DECISION DELEGATED TO HEAD OF PLANNING

Application No:	H14-0893-22	Applicant:	Anglia (UK) Ltd.
Proposal:	Details of scheme to deal with external materials, design & position of external meter boxes, gas flues & soil vent pipes, existing & proposed site levels & proposed floor levels and means of foul & surface water disposal (Conditions 4, 5, 7 & 9 of H14-0295-22)		
Location:	The Anglia Business Centre Mill Green Road Pinchbeck		
Terminal Date:	18th December 2023

Drawing
Proposed managers dwelling - Floor plan

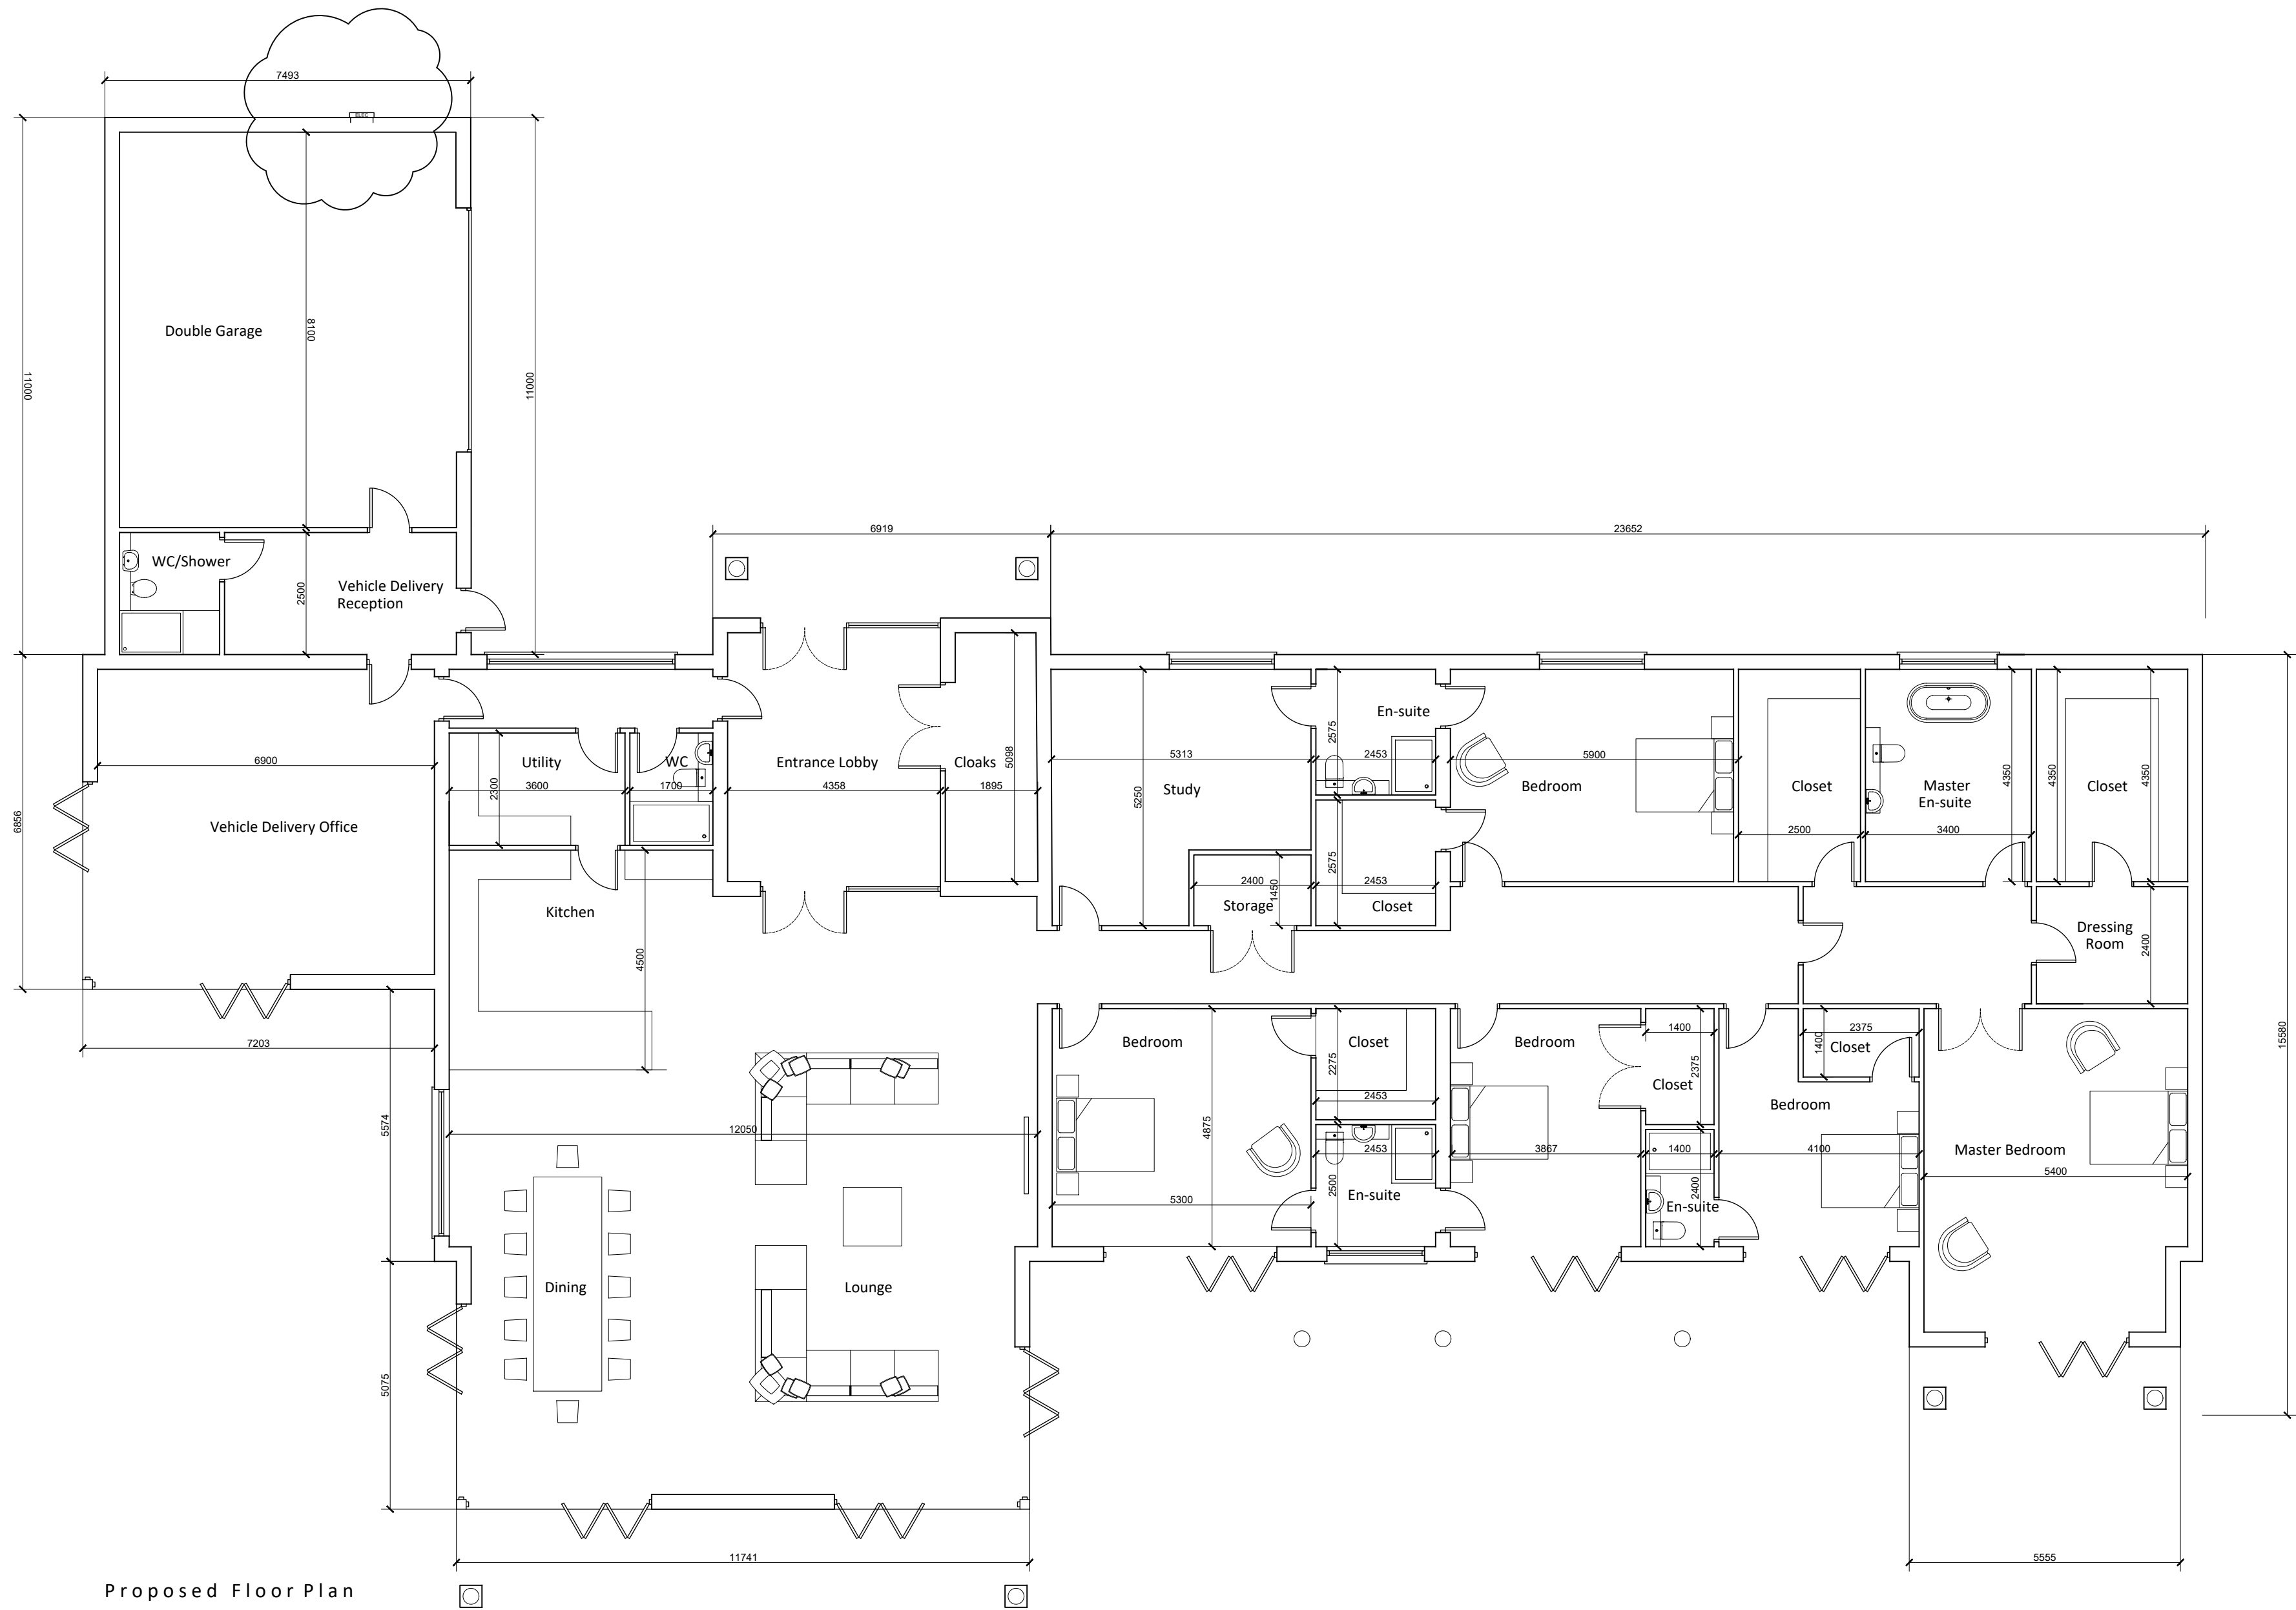
The proposed electricity meter box location is on the north facing frontage wall of the dwelling, but remains visually discrete and allows for easy access. For the storage building, the proposed electricity meter box location is on the north facing frontage wall of the dwelling, but remains visually discrete and allows for easy access.

The existing site levels around the dwelling are around 2.95m AOD to 3.04m AOD. The finished floor levels of the dwelling will be set at 3.30m AOD, with the surrounding land unaltered. There is not considered to be an overlooking, overshadowing and overbearing impact from the single storey dwelling levels by virtue of the separation distances to other dwellings and the remote location of the application site.

Drawing
Proposed Site Plan

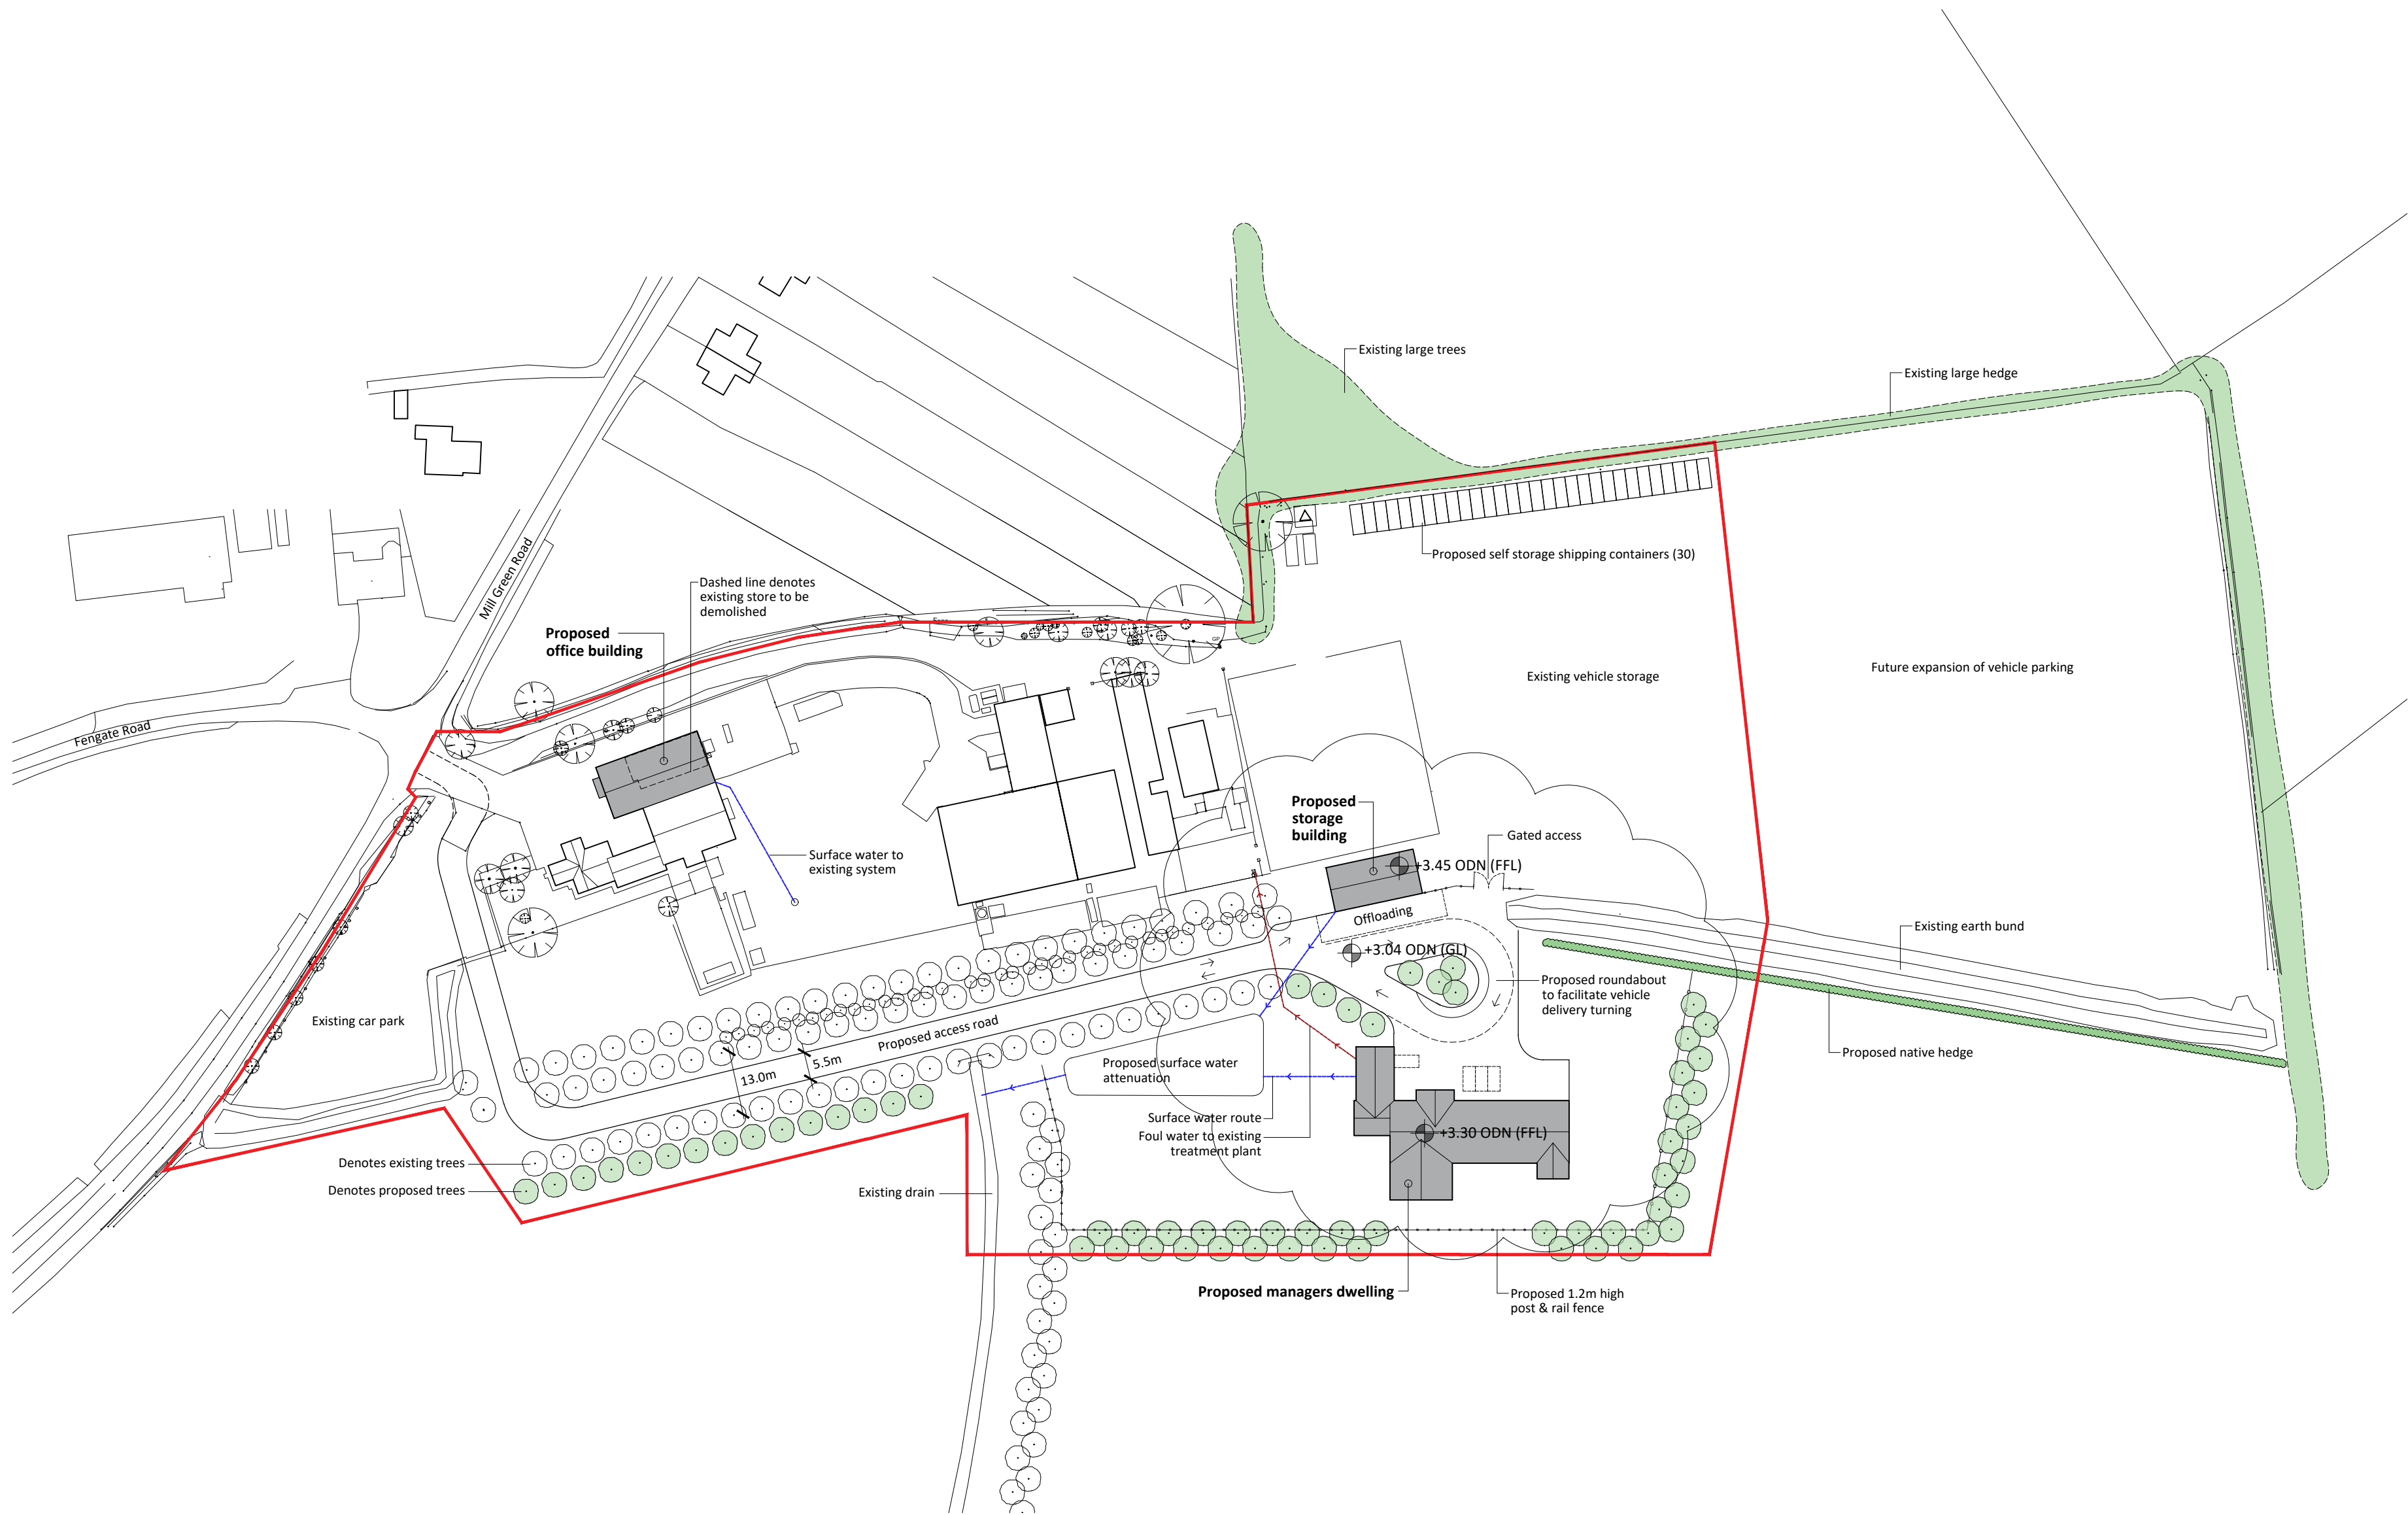
The existing site levels around the storage building are between 3.05m AOD and 3.23m AOD. The proposed finished floor levels of the building will be set at 3.45m AOD, with the surrounding land unaltered. The storage building is to be 4.3 metres in height. As the storage building is sited to the north of the dwelling and the sun traverses the sky on a southerly trajectory from east to west, there will not be an overshadowing or overbearing impact on the property.
